DRB CASE ACTION LOG (PREL/FINAL)

DRB Application No.: 09DRB-70047 Project # 1004617
 Project Name: LA VICTORIA 670-0593
 Agent: JACK'S HIGH COUNTRY Phone No.:

DRB Comments

RE: Lot 100, La Victoria Subdivision

NOTE: EXISTING BUILDINGS SHOWN ARE AS OF JULY, 2009.

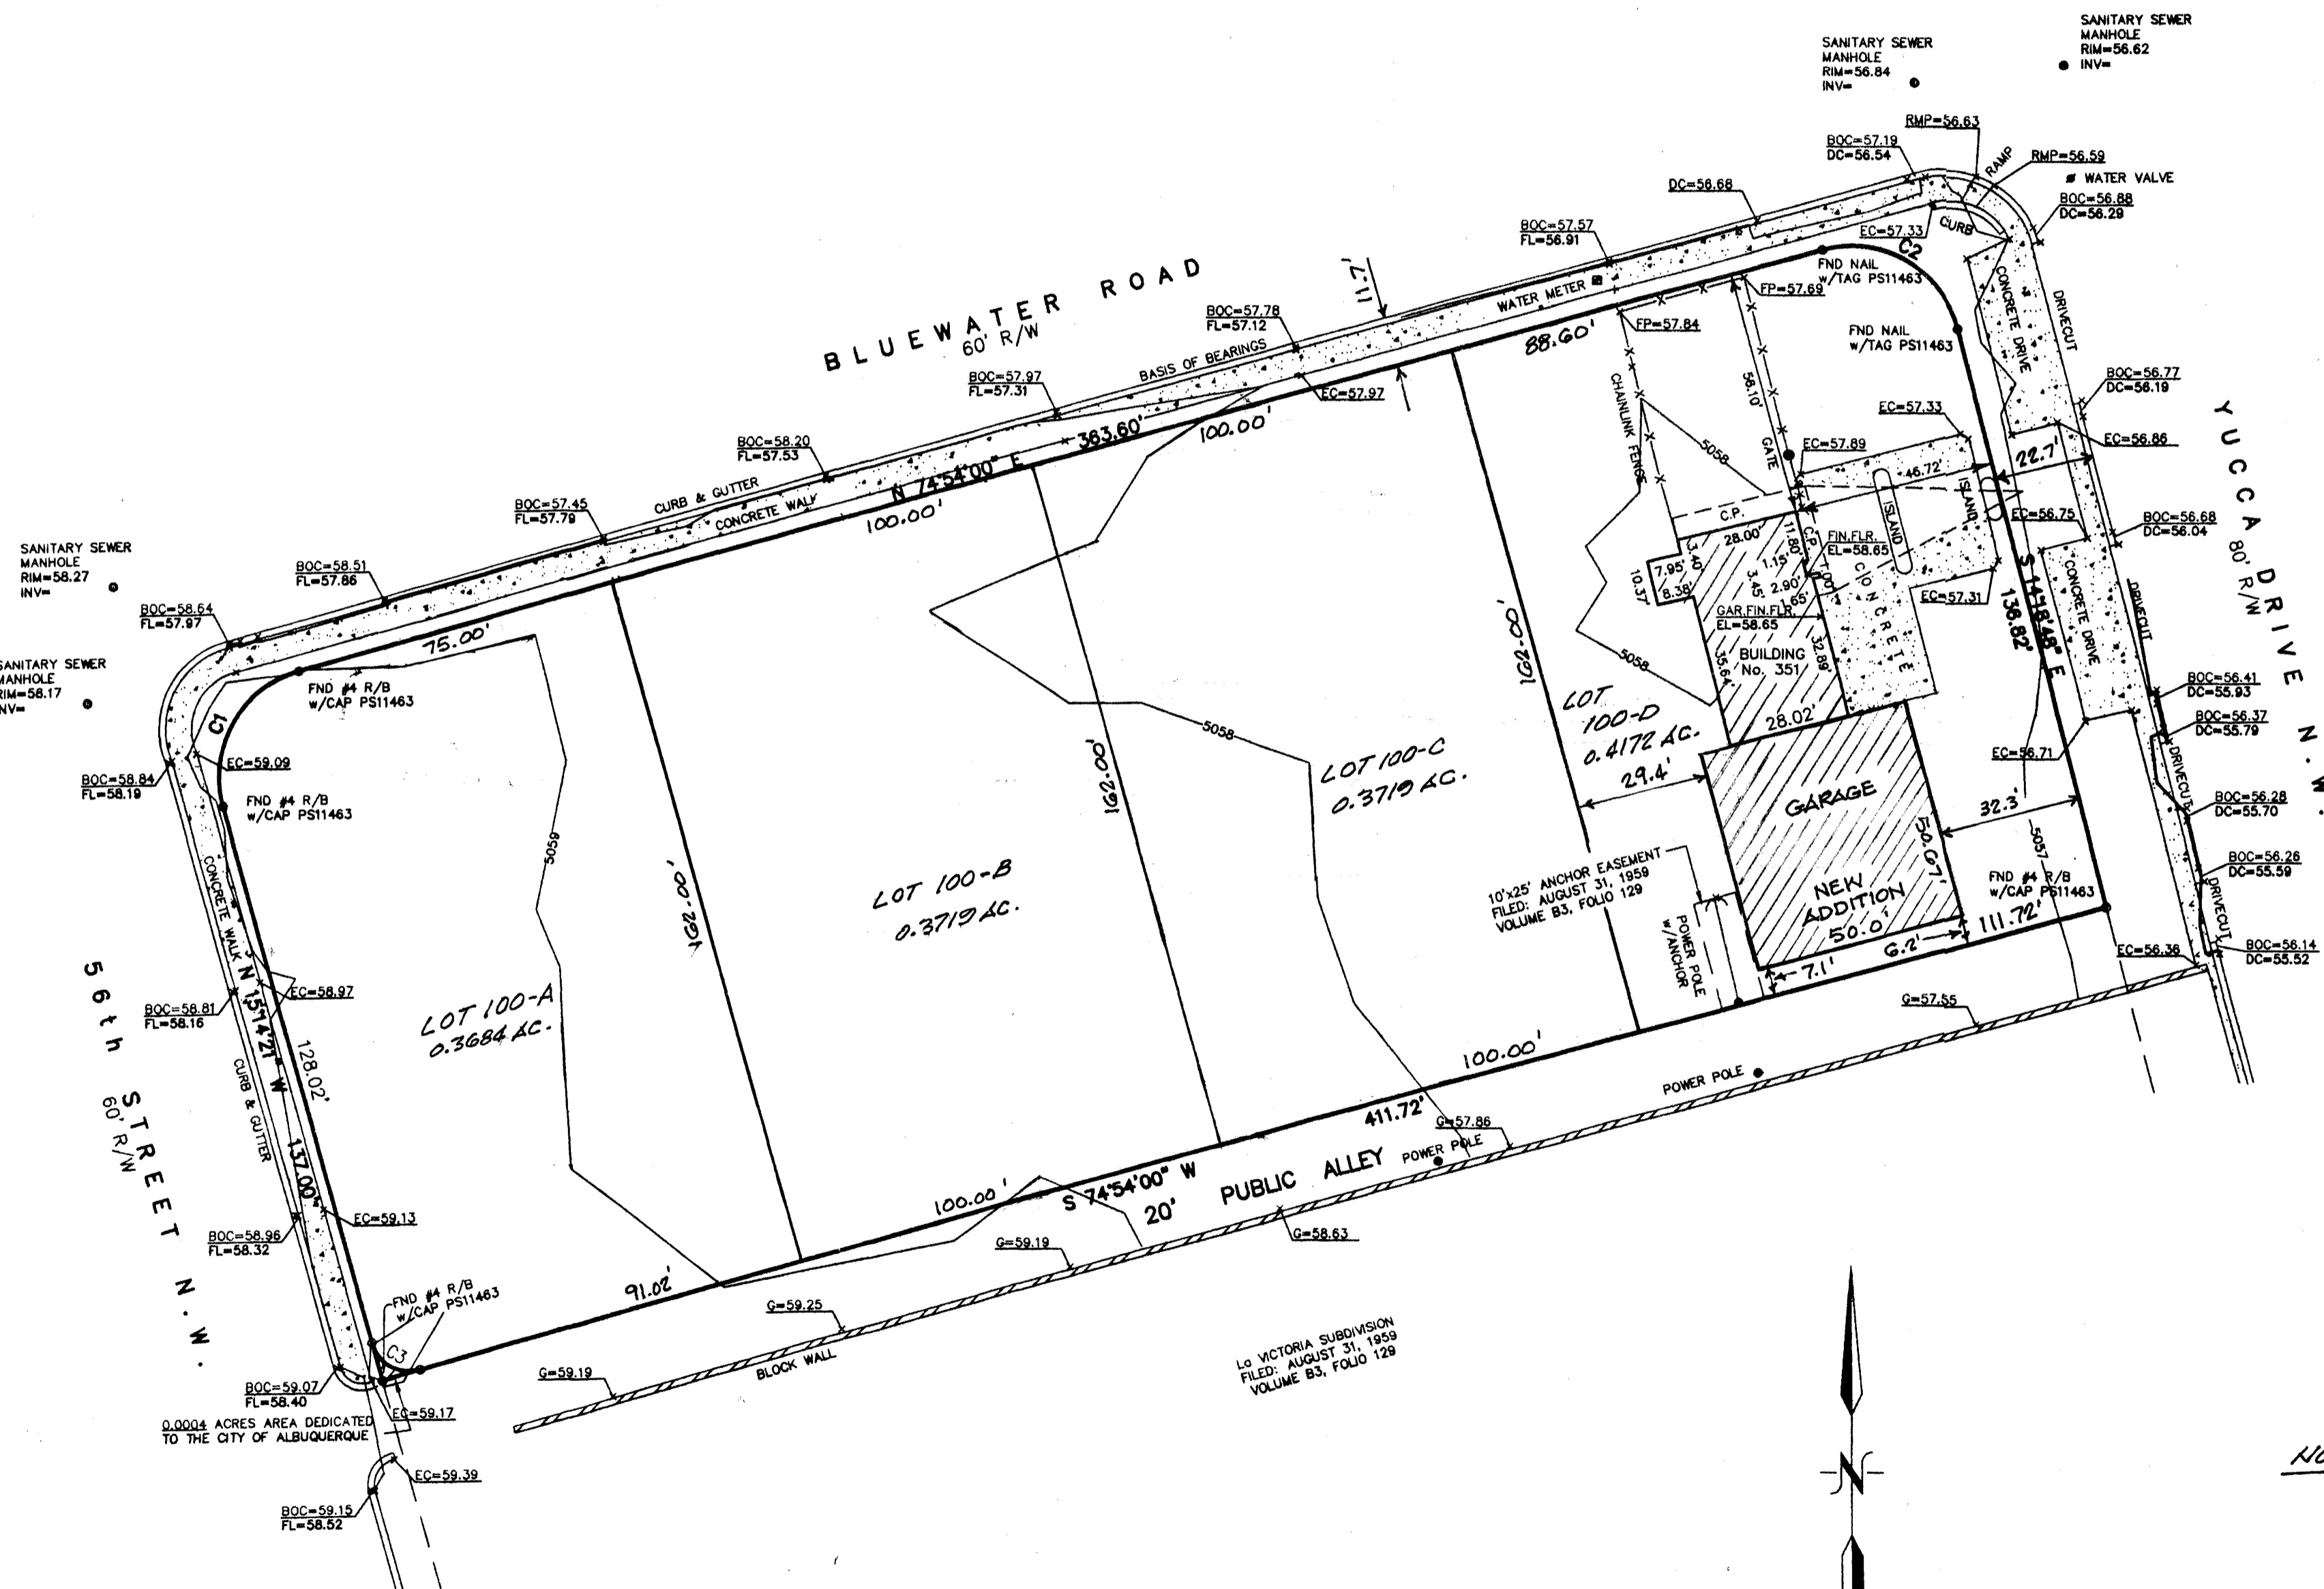
PLANNING (Last to sign): - rite sketch with new lot lines
- photo of retaining wall

A site sketch is needed to show that existing building(s) comply with setback requirements from proposed lot line.
